Town & Country Planning Act 1990 (as amended)
Town and Country Planning (Development Management Procedure) (England) Order 2015
Approval of details reserved by condition imposed under FG/115/17/PL relating to condition 7-surface water drainage.
Paddock House 44 Ferringham Lane Ferring BN12 5LU

Arun District Council have decided to **REFUSE details reserved by condition for the following reasons:**
Following the recommendation from our Drainage Engineers, the condition cannot be discharged at

Concrete Block Permeable Paving

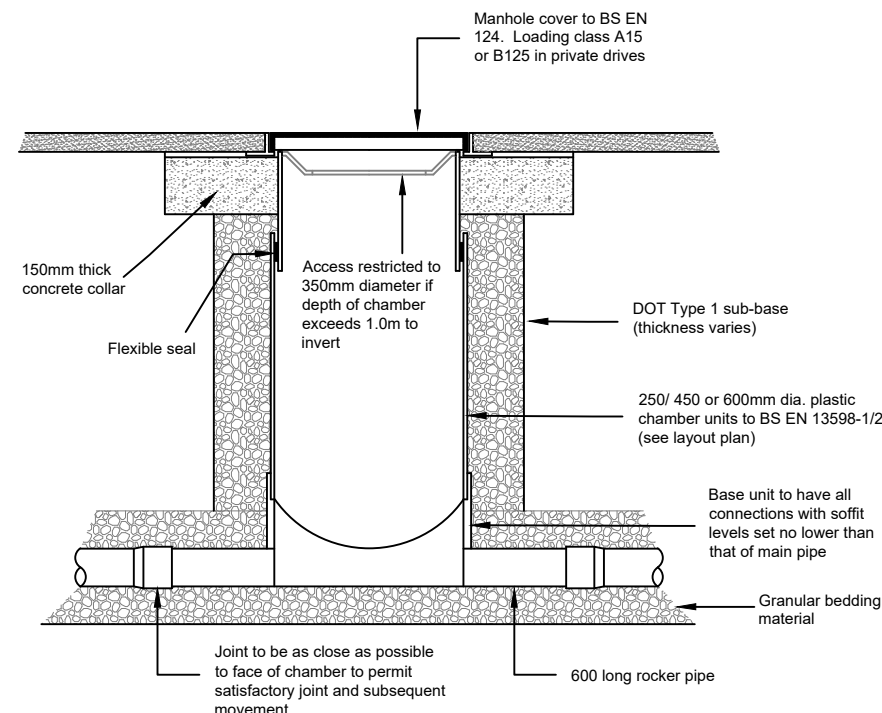
- If the drainage calculations only account for runoff draining from impermeable surfaces, then the calculations should apply a CV of 1.0.
- Groundwater monitoring results show groundwater levels ~500mm below the surface. The base of the ring soakaways, and geocellular soakaway, are located below this level. The base of the permeable surfacing sub-base is not confirmed and may also be below this level.
